Submission in opposition
Project Mars Data Centre – 12 Mars Road, Lane Cove West
Application No. SSD-82052708

1. Executive Summary

DRAWING TITLE
SITE PLAN

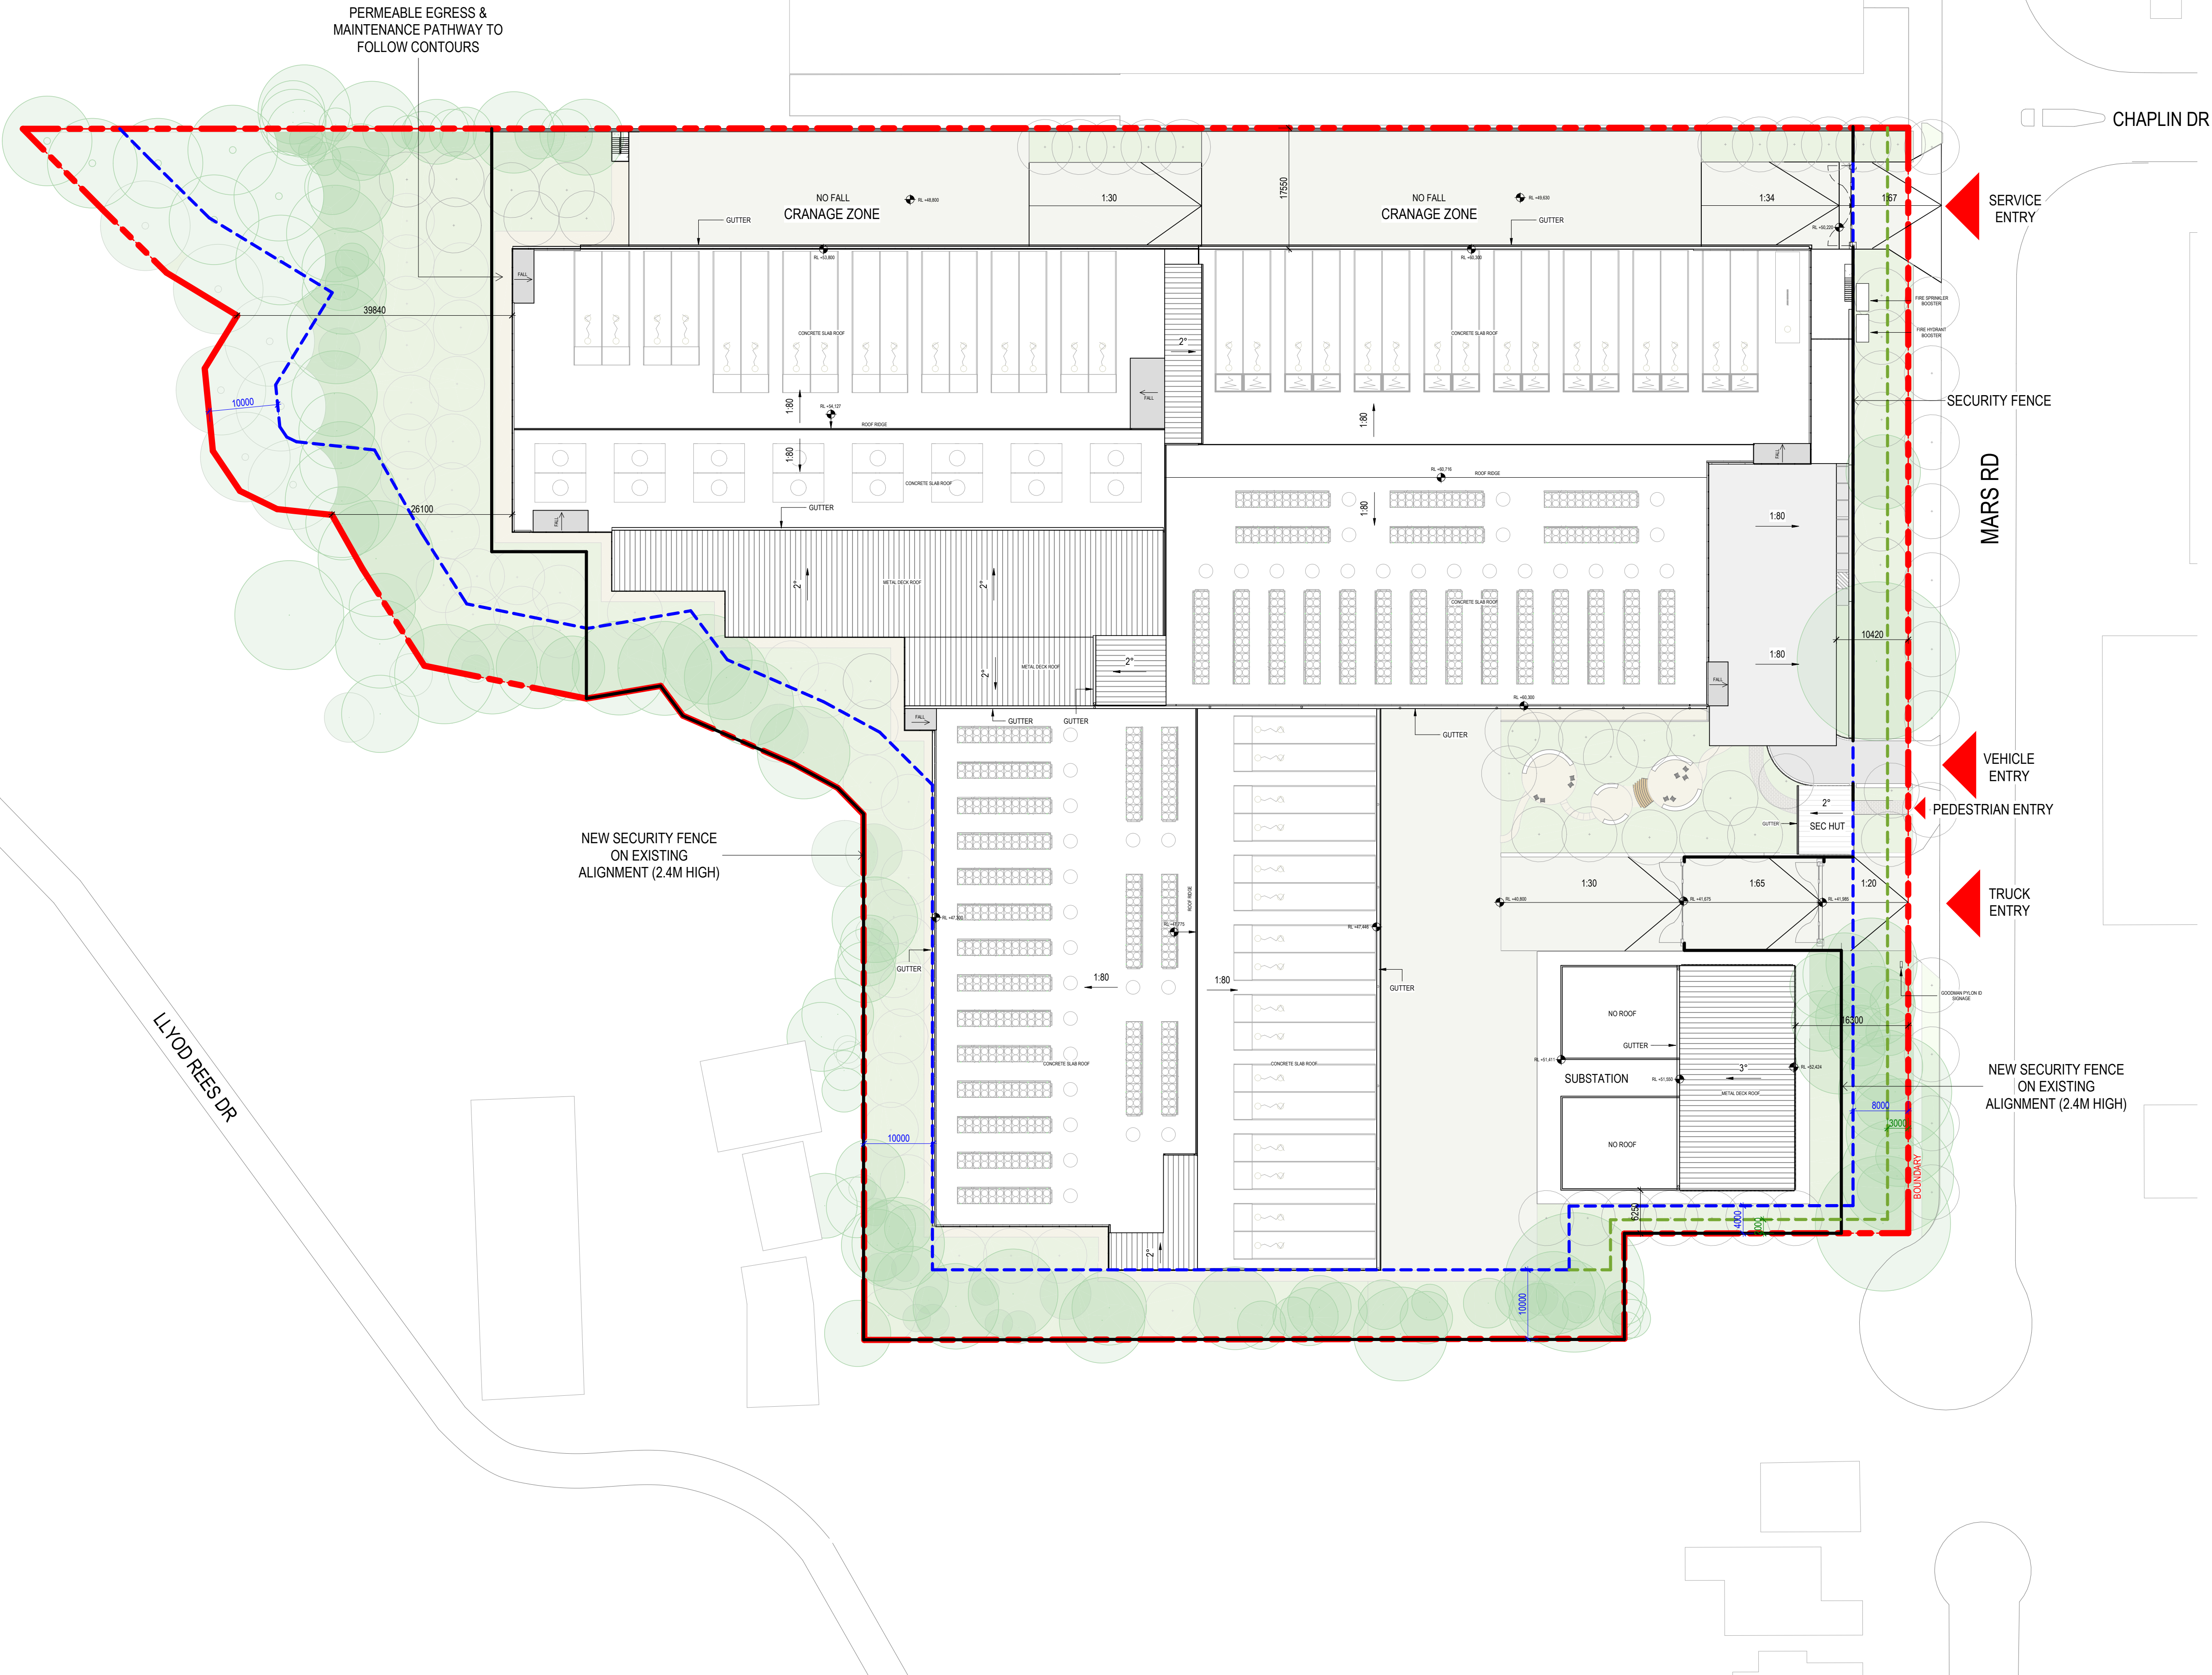
The setbacks of the proposed building are smallest on the eastern boundary, which is the boundary separating the data centre from residences. It is inconceivable to me that this should be the boundary with the smallest set back. Further, the driveway which is closest

to residents has been designated for access by trucks and other heavy vehicles. This is thoughtless at best.

1 EAST ELEVATION
1 : 500

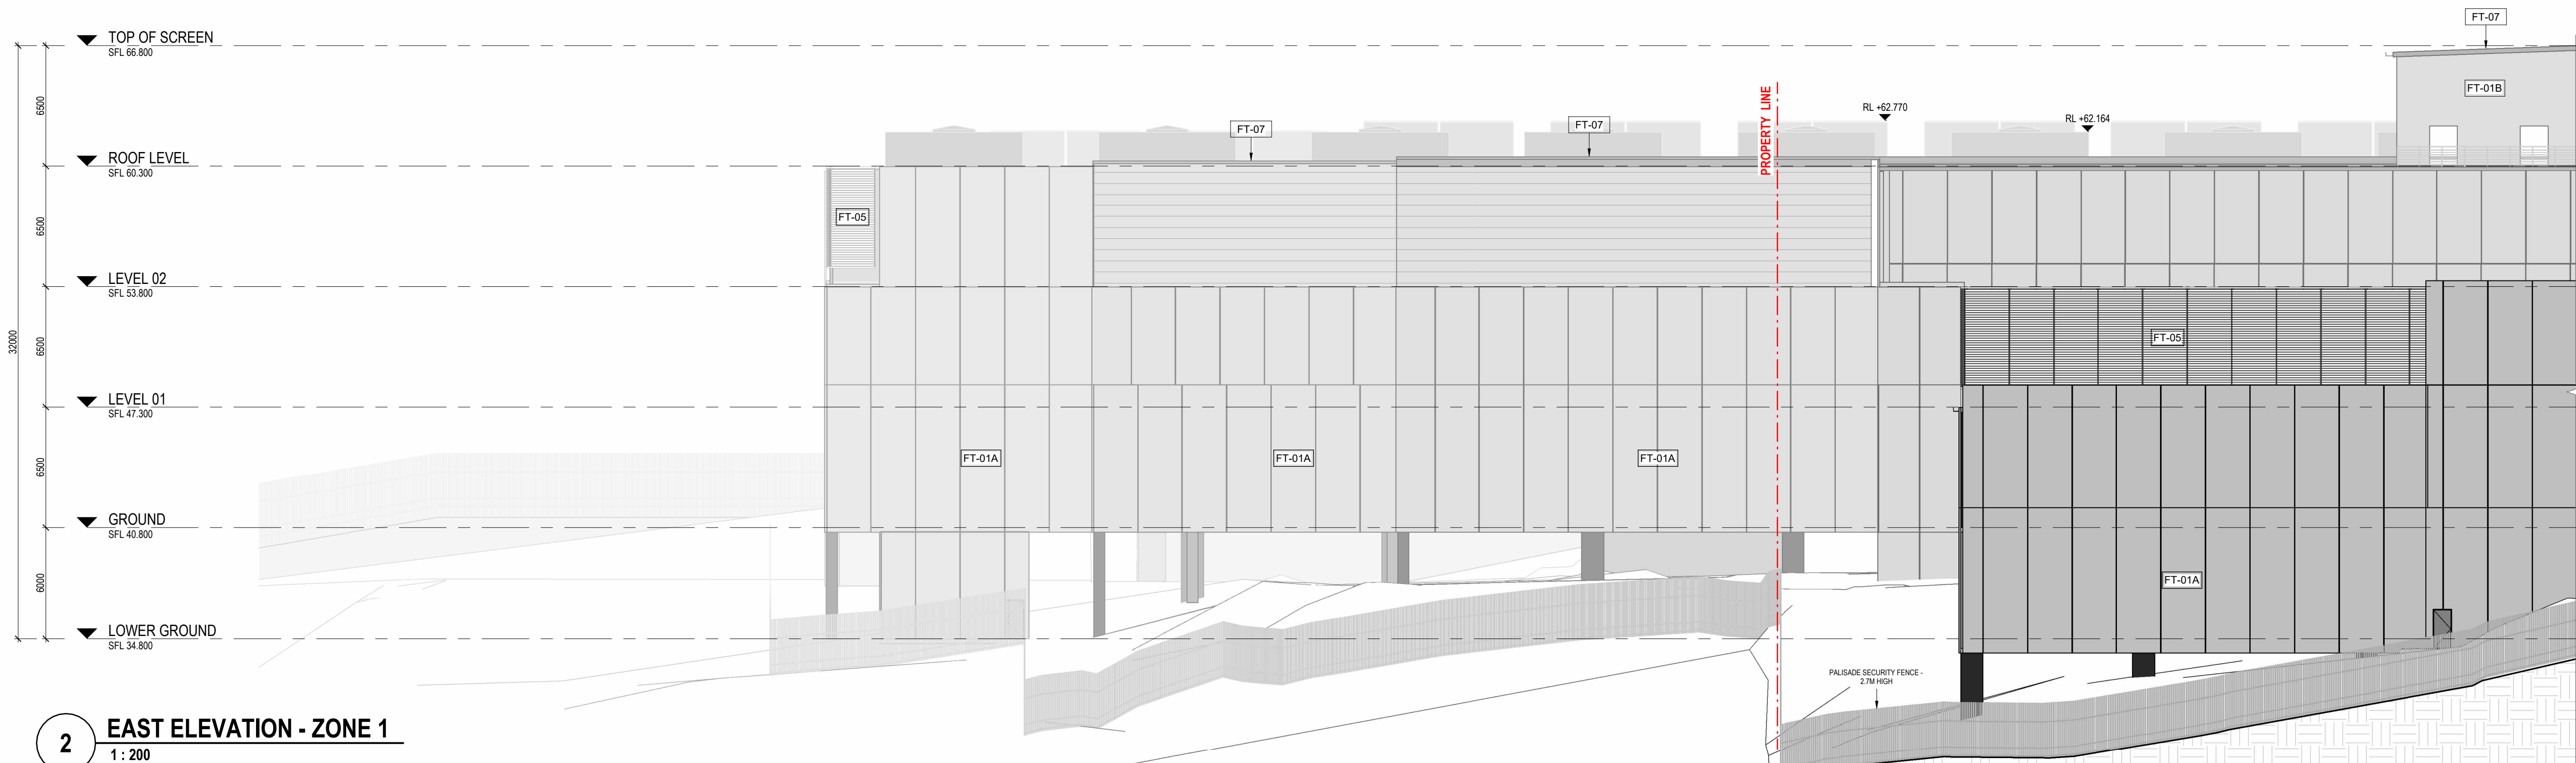
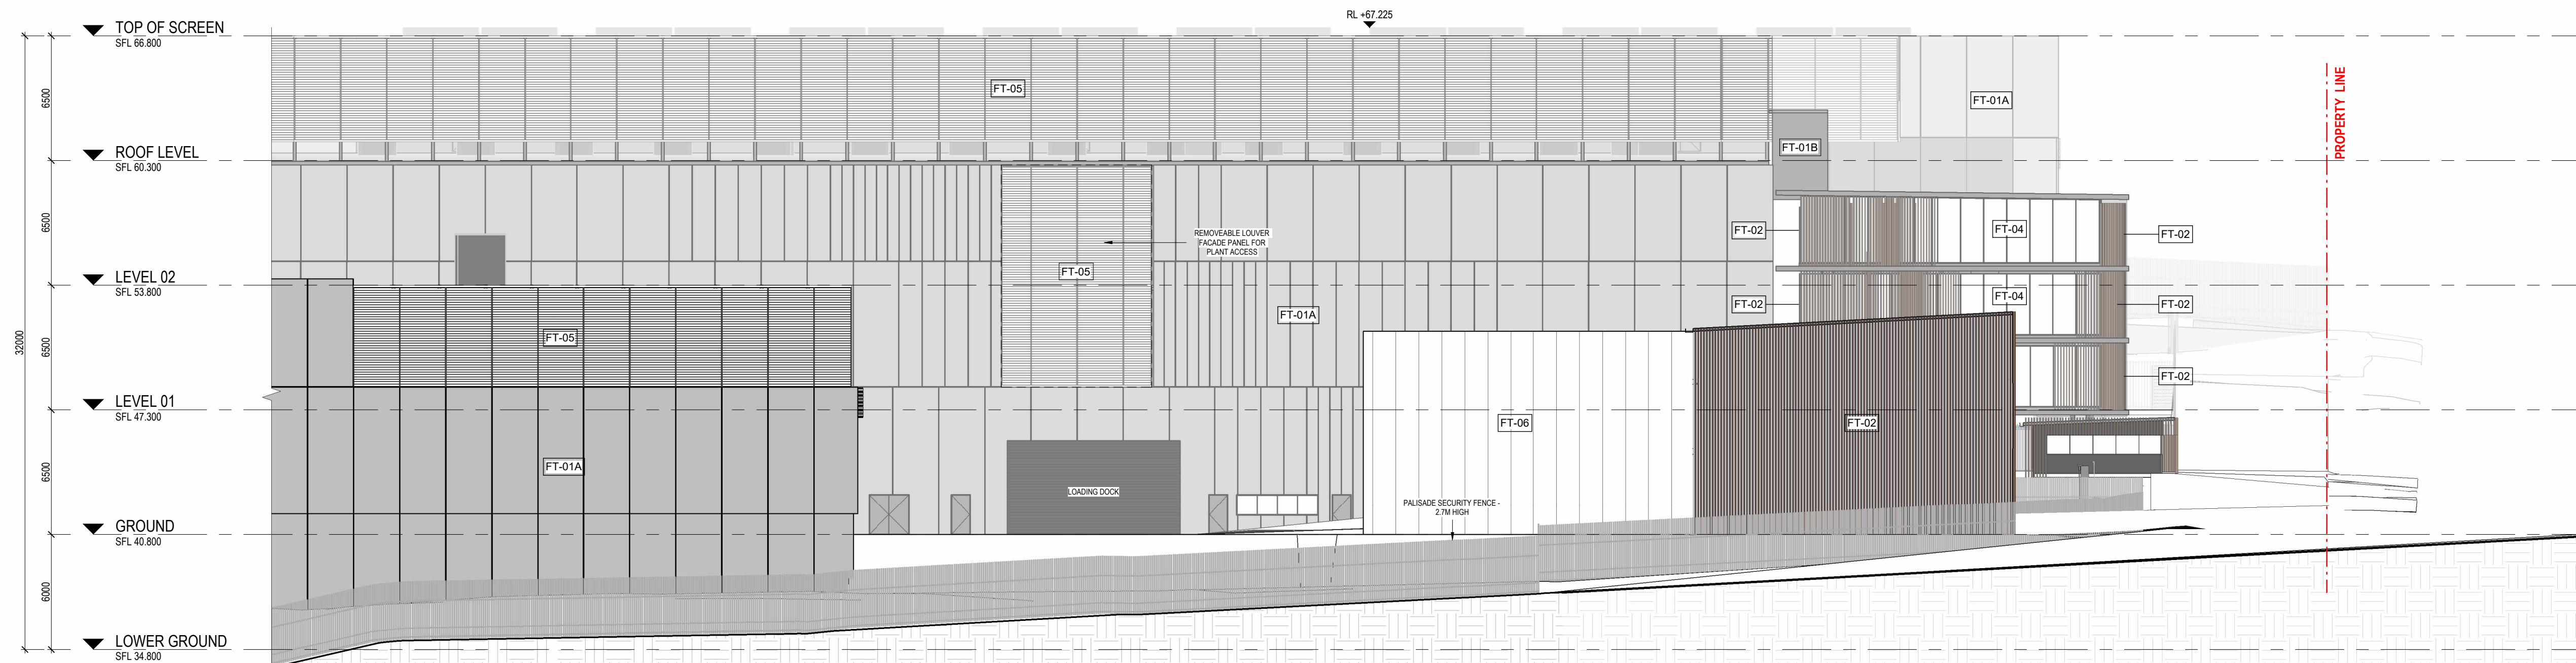
- the staggering fact that the proposed development at 28.3m high exceeds the 18m maximum building height control by 10.3m (**ie, exceeds the maximum permitted height by a whopping 57%**) and yet Urbis disingenuously states, without justification, that this will not result in **any** adverse environmental impacts (p56 EIS);
- the mechanical plant (generators, chillers and water towers) will be located at roof level – **does this mean this mechanical plant (and louvres) do not count as part of the height of the development as they sit on the roof, so the actual height of the building and plant is greater than 28.3m?**;
- the proposed data centre will be taller than **all** surrounding buildings in the Lane Cove Business Park.

Goodman and Urban propose this height 'variation' (ie, exceedance) to 'satisfy the operational requirements of the data centre'. That is to say, the height control must be increased to accommodate the data centre, rather than the proposed data centre design

being modified to accommodate the height restriction. **Again, this is the tail wagging the dog.**
